November 25, 2020

Re: Addendum to Pavement Design Report
Ponderosa at Lorson Ranch Fil. No. 3
Old Glory Drive
El Paso County, Colorado

*Pavement Design Report
El Paso County SF-20-016
RMG Job No. 178680
Dated November 16, 2020*

**Compressive Strength vs. Cement Content**  
**Ponderosa at Lorson Ranch Filing 3**  
**RMG Job No. 178680**  
**CTS Mix Design Target Values A-7-6 Soil**

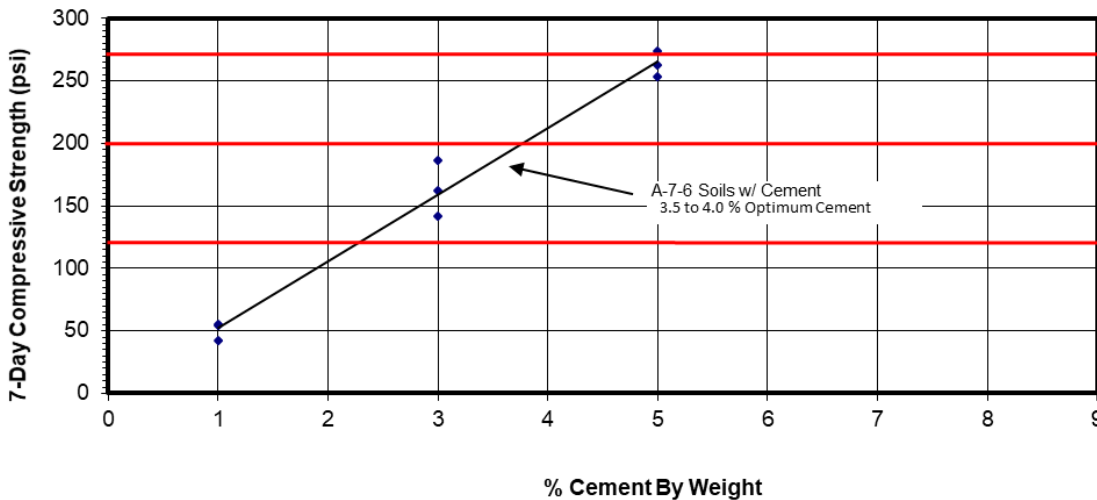
On Page 5 of the referenced report, the paragraph between the charts contains an error in the text. The lower strength limit is given as “160-psi”, which is incorrect. The correct lower strength limit is 125-psi.
